From: Grant Freeman [REDACTED]
Sent: 03 September 2015 09:35
To: Simon Davis
Subject: Re: Ref BN/23/15/PL 4 Lake Lane, Barnham

Following your email on the 28th August R.E. 4 Lake Lane, Barnham, and the subsequent comments, please find attached a revised set of drawings showing a reduction in the window recesses and glazing to the front elevation.

Dwg No: 052-D-02 - REV1

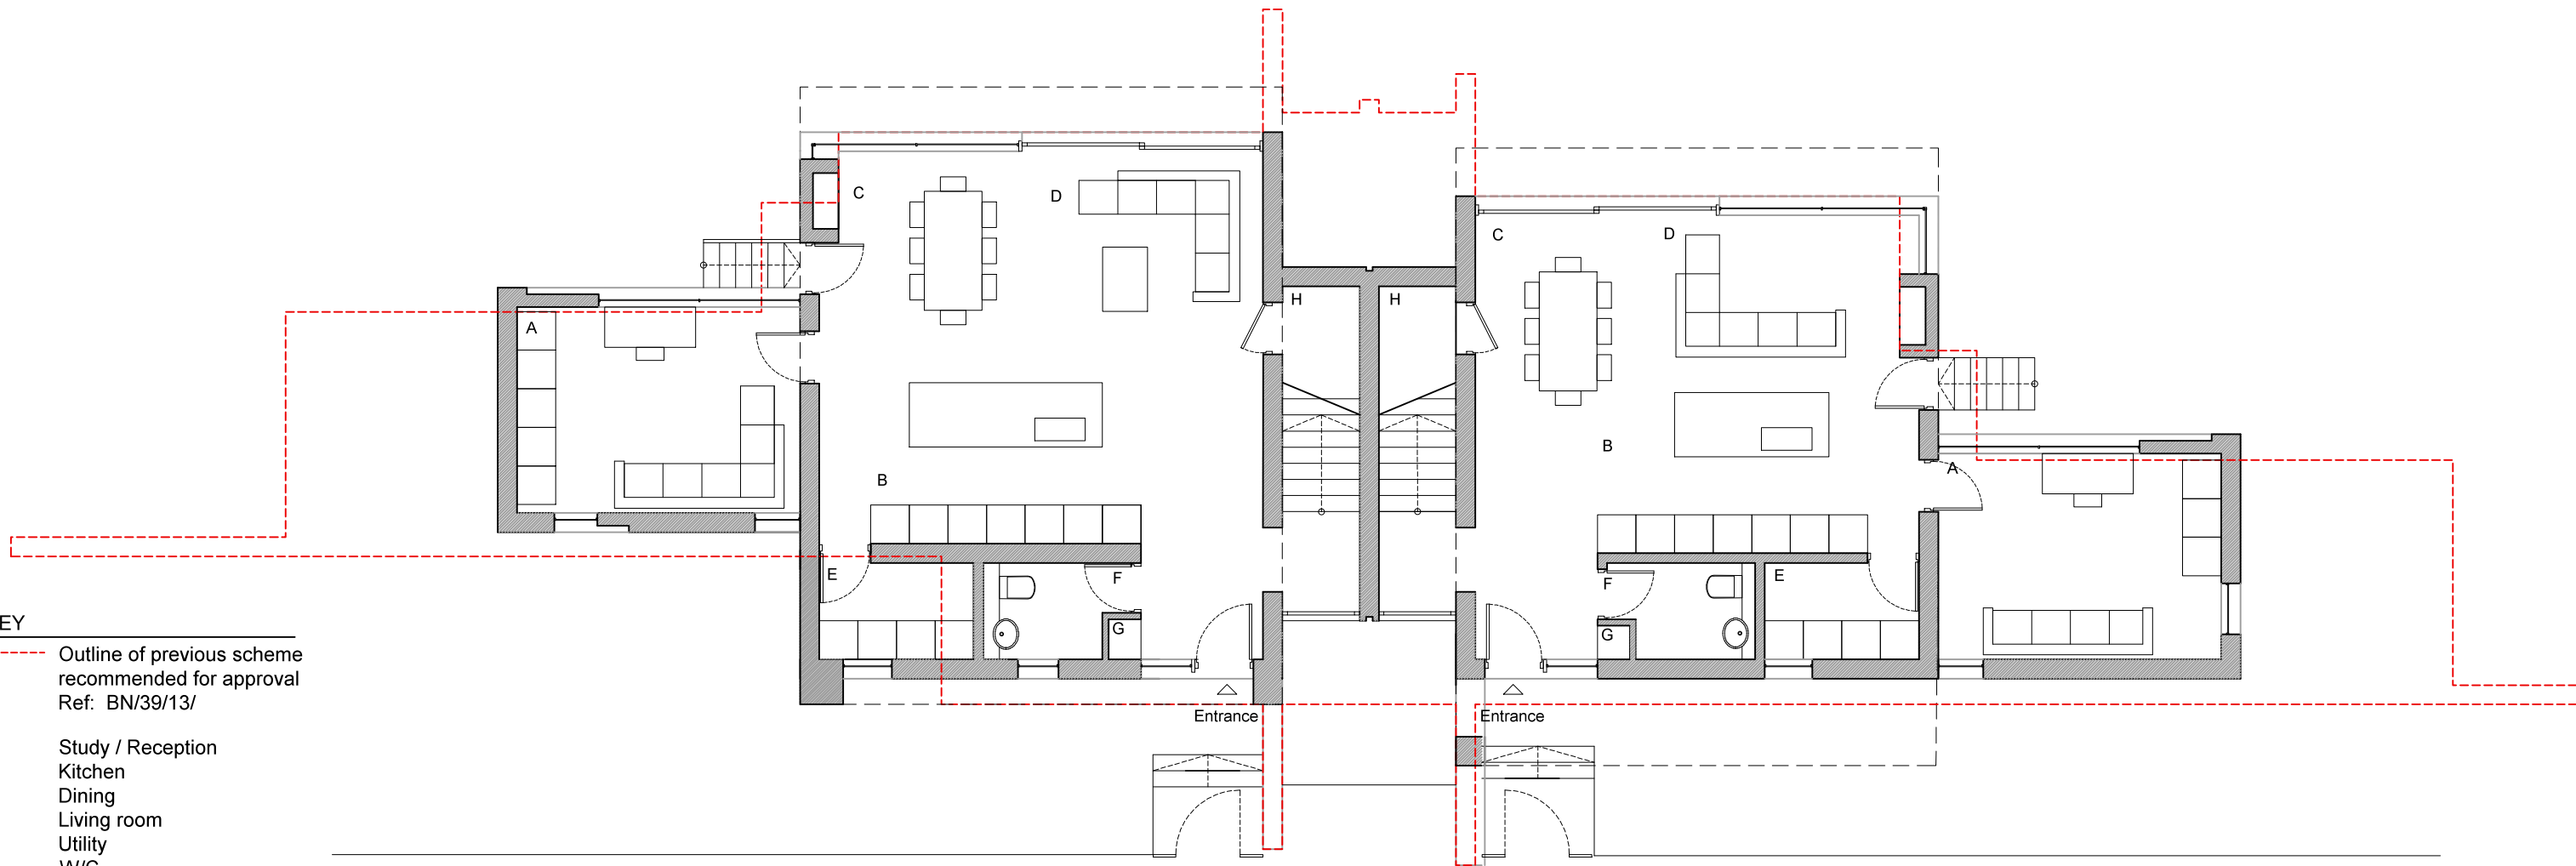
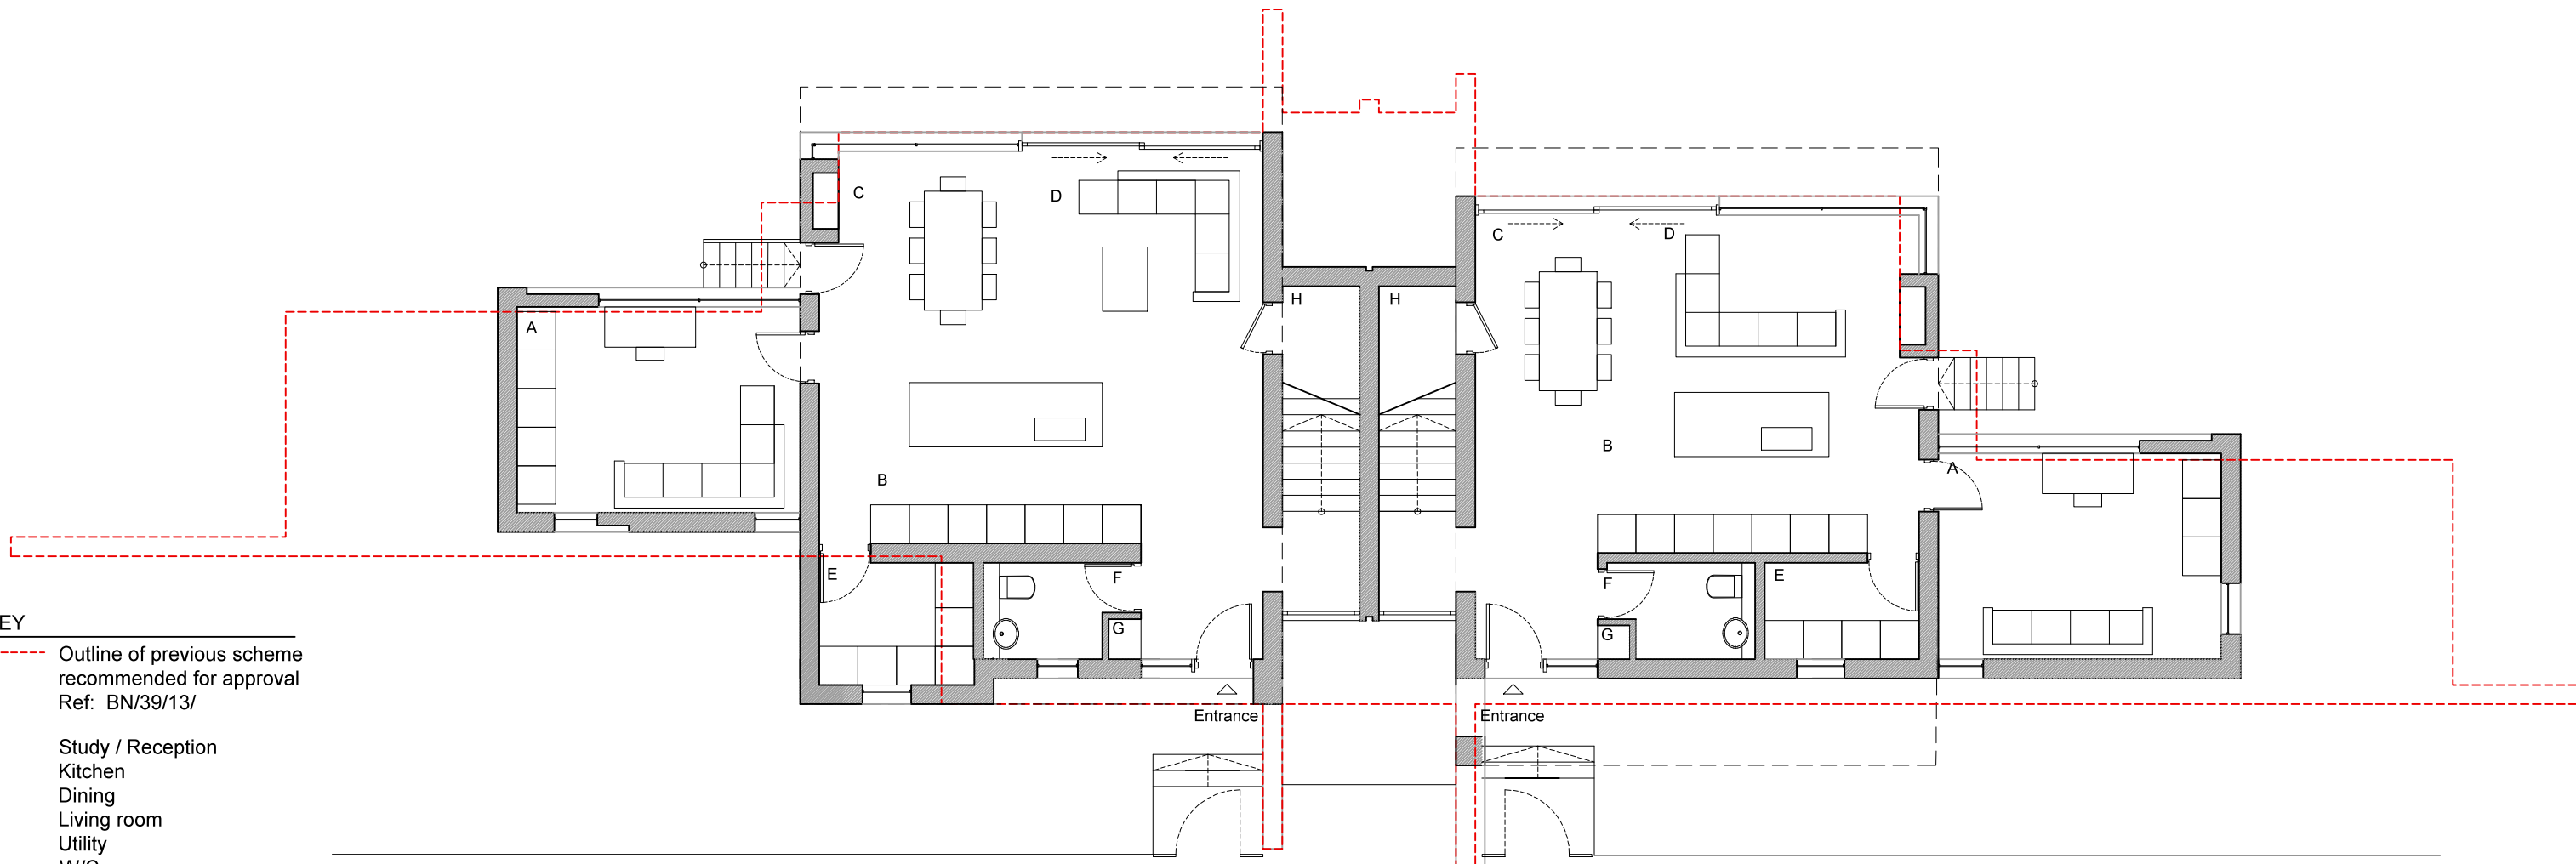
I cannot promise anything with regard to Committee. Yes to the reduction in the ground floor recess as well as those recesses at first floor.

I have just had a brief chat with the Head of Development about the application. We feel that you have made a big improvement on the last application but have a concern about the size of the front recessed 'window' openings and in order to attract a positive officer recommendation, we would ask if you could reduce the size of these. I note that the actual glazed parts are already quite small and our concern is rather with the actual recessed areas. The rear windows are fine.
